RE: 9431/APP/2017/131

Please find enclosed revised drawing and my response to the drainage officer comments.

PROJECT	1 PARKFIELD AVENUE, HILLINGDON, MIDDLESEX, UB10 0DF
DRAWING TITLE	SITE LAYOUT PLAN
DRG NO.	14254-P04
DATED	25-03-2015
APPROVED BY	PL

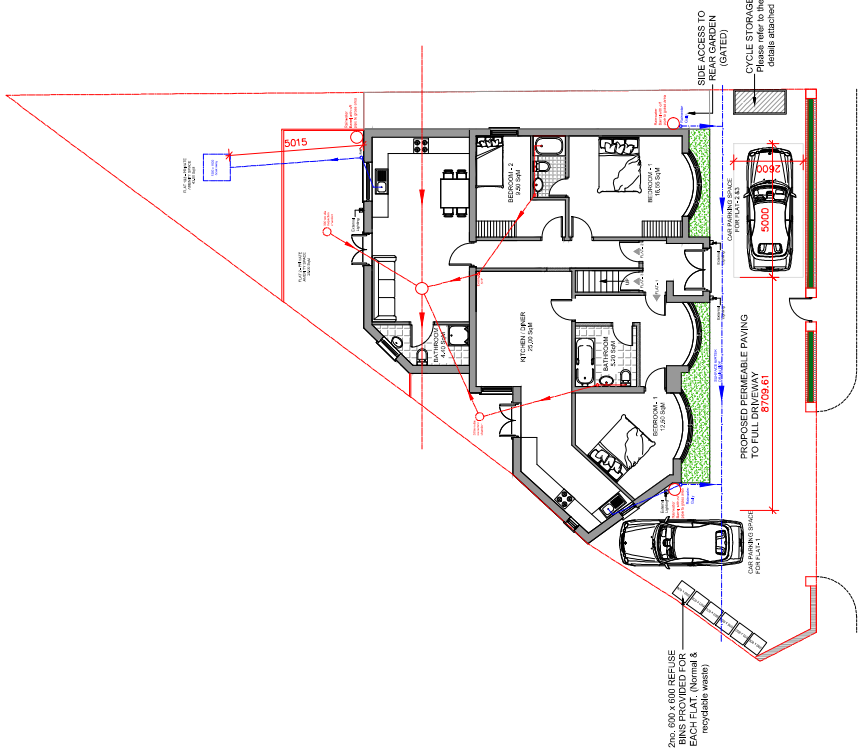
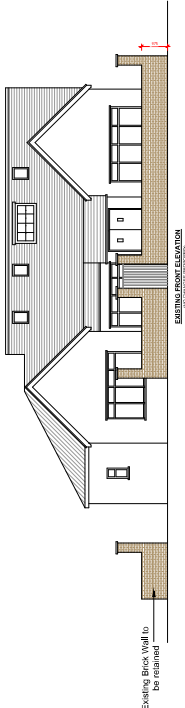
I have now received the attached updated comments in respect of this plan which will need to be addressed to discharge this condition

- Drawing revised to show front driveway to have permeable paving's
- Rainwater barrels are proposed at the front and the rear to reuse rainwater. Over flow pipe is connected to the barrel with outlet on the soft landscape area
- Rainwater will be collected in the barrels and the water would be utilised for watering plants, grass, washing bin area etc.
- Due to the scale of the site, it will be managed by the client. There is no mechanical system proposed for the site where maintenance agreement is required.
